## **SSD 8175 – WESTERN SYDNEY STADIUM (STAGE 2) - EIS**

## ATTACHMENT A

#### WESTERN SYDNEY STADIUM STAGE 2 – CONSTRUCTION AND OPERATION

#### Rock Music Noise

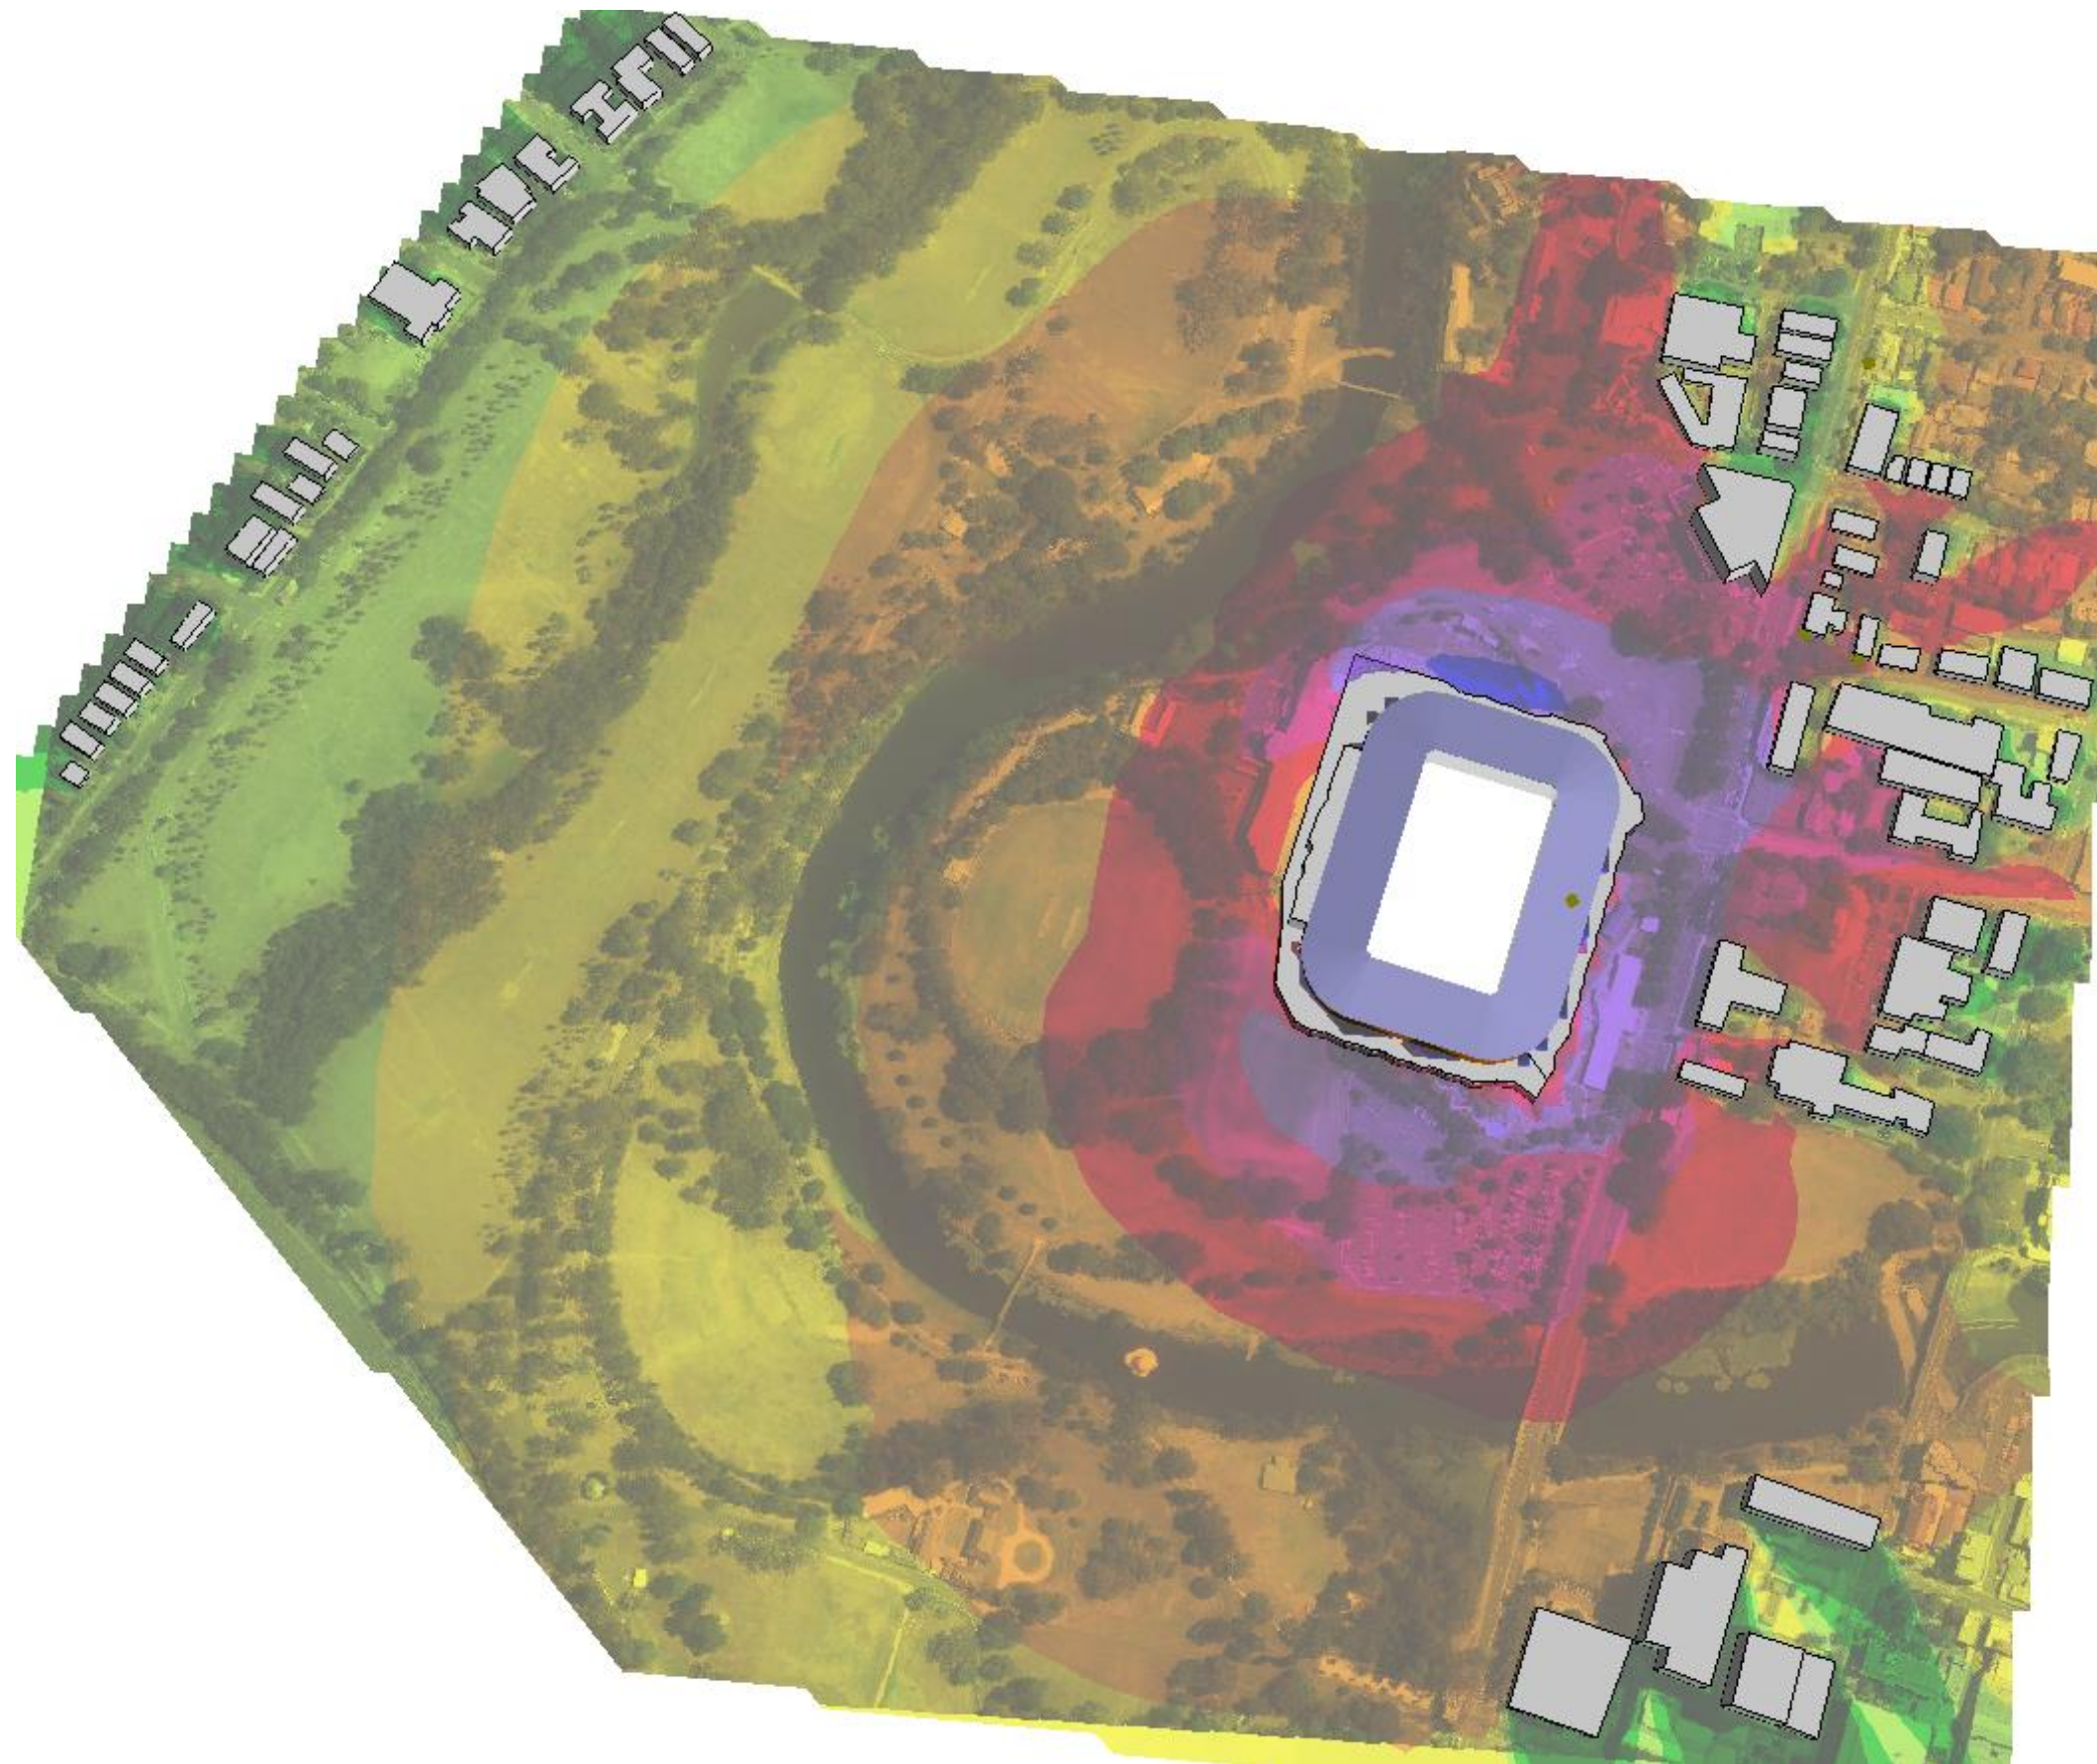
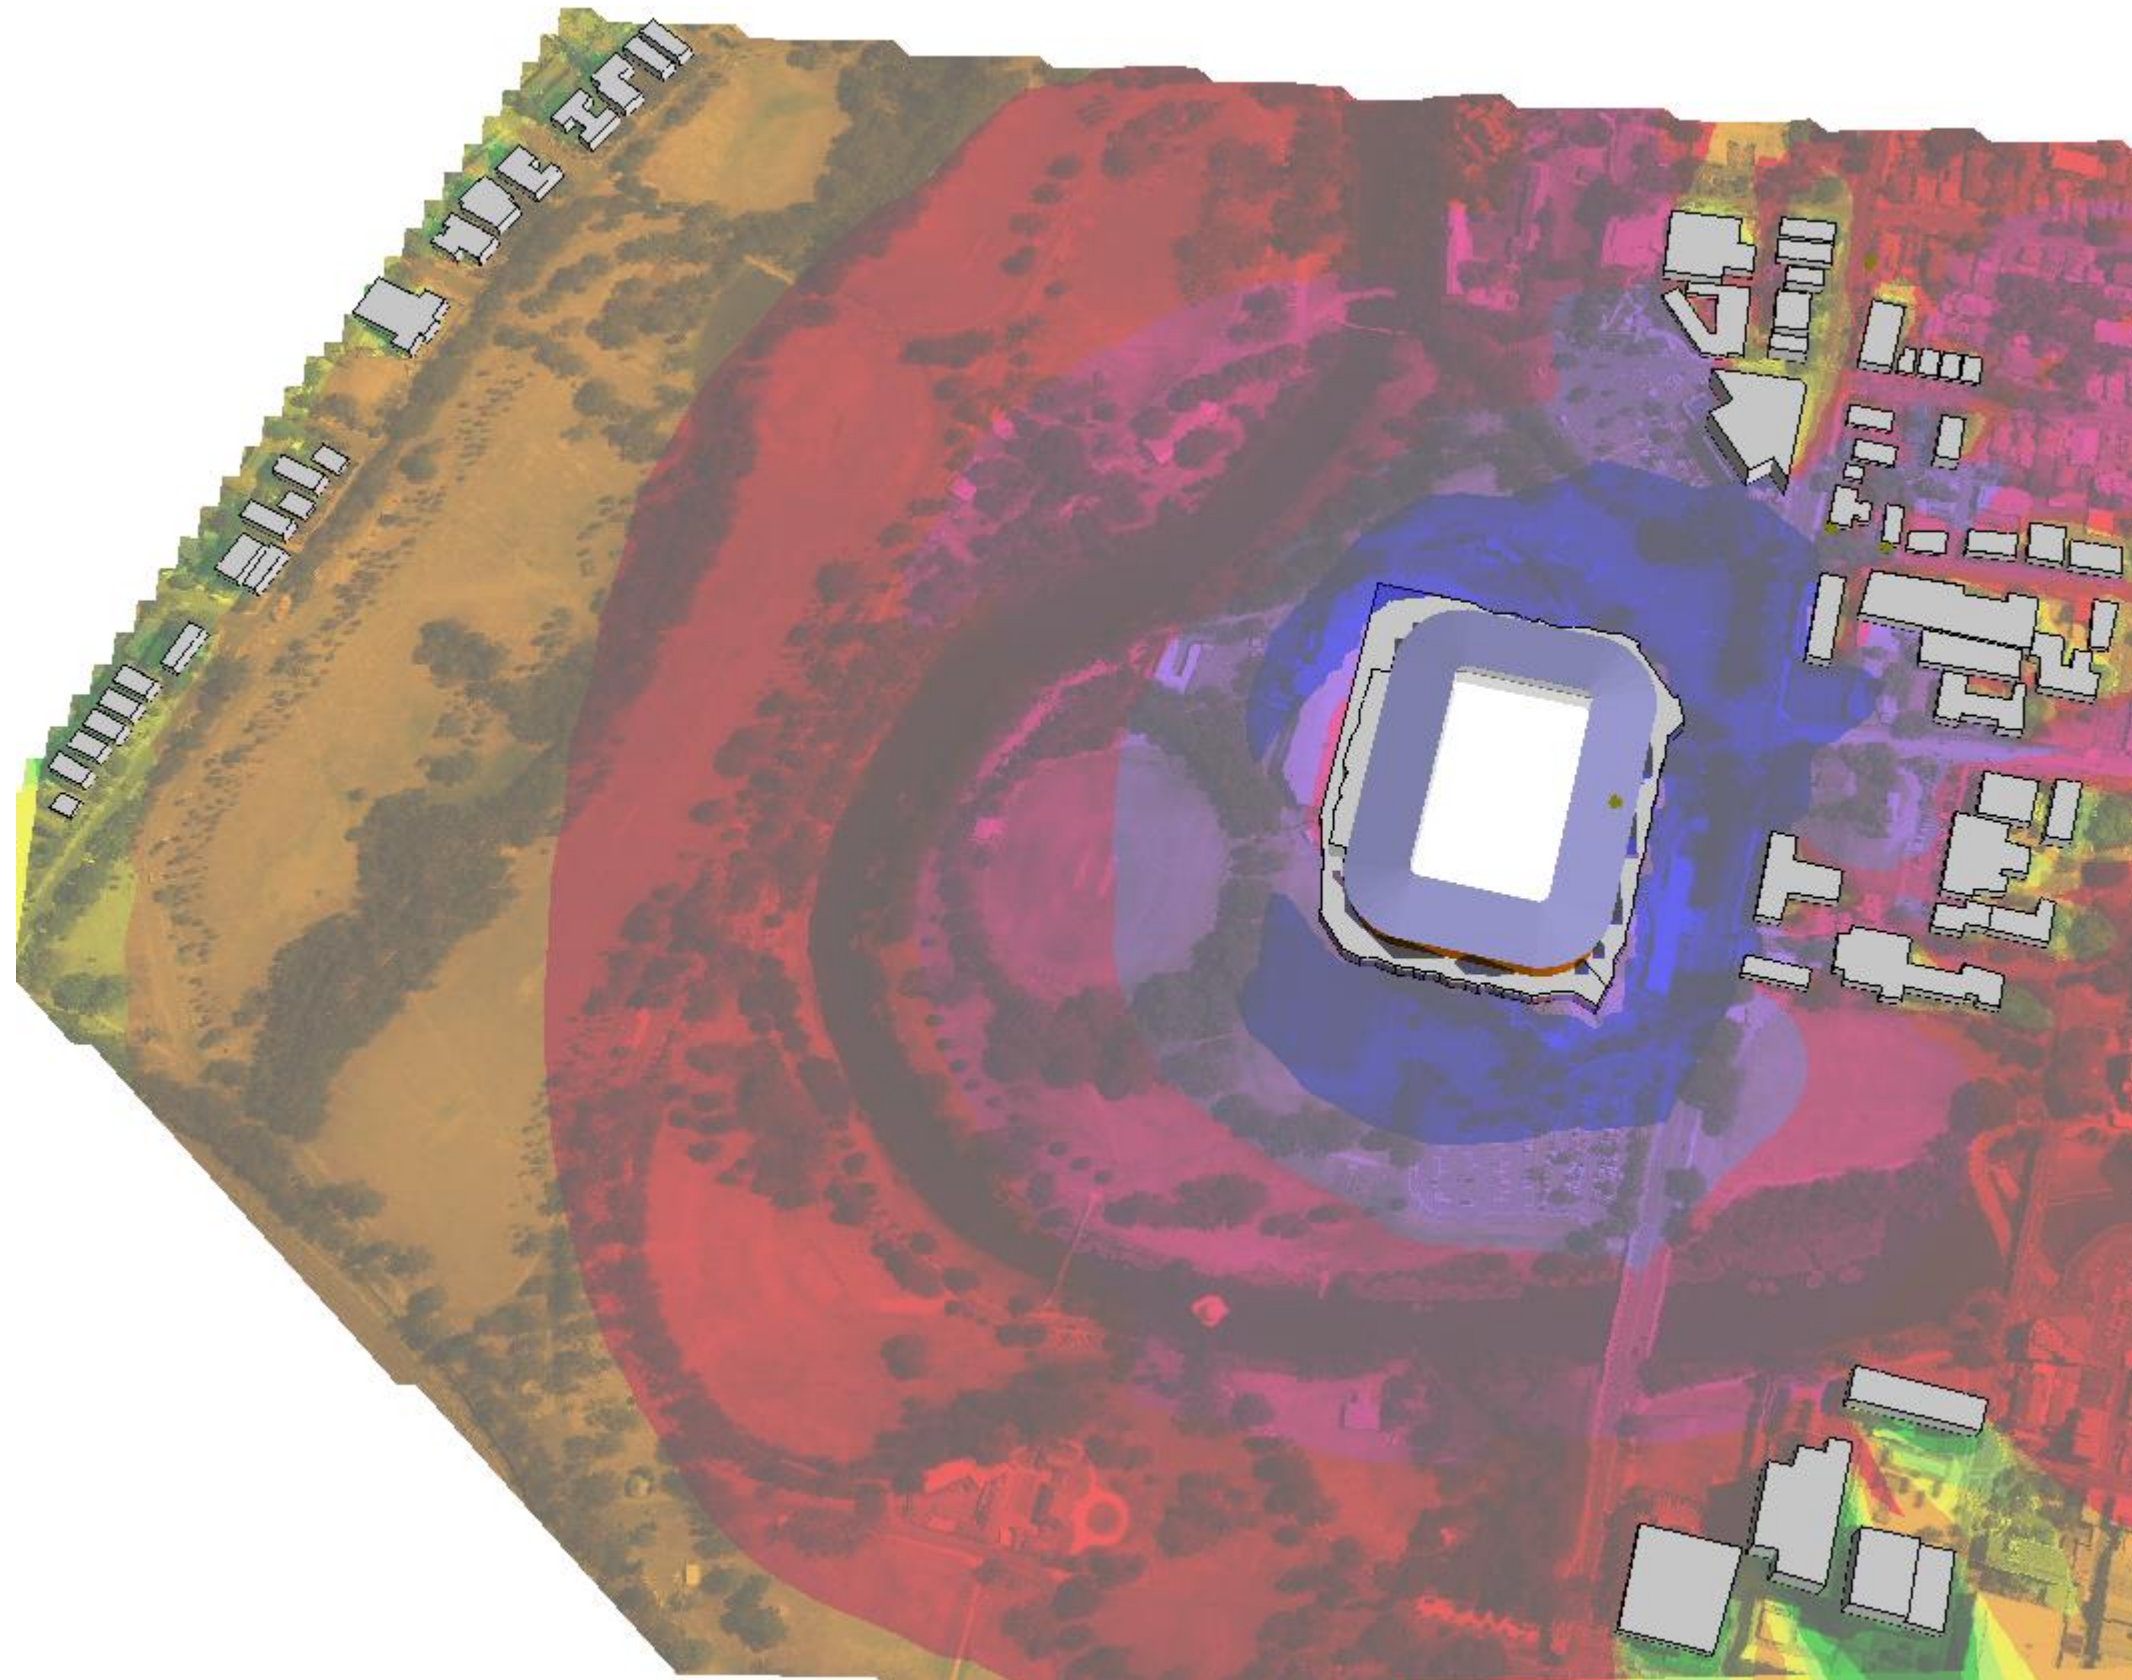
The EPA acknowledges that whilst predicted operational noise contours are presented (developed using proprietary noise modelling software), EIS Appendix S does not include –

- (a) tabulated data using the various recommended A and C weighted noise descriptors required to facilitate proper evaluation of those predicted noise impacts,
- (b) details of predicted day-time noise impacts on non-residential noise sensitive land uses.
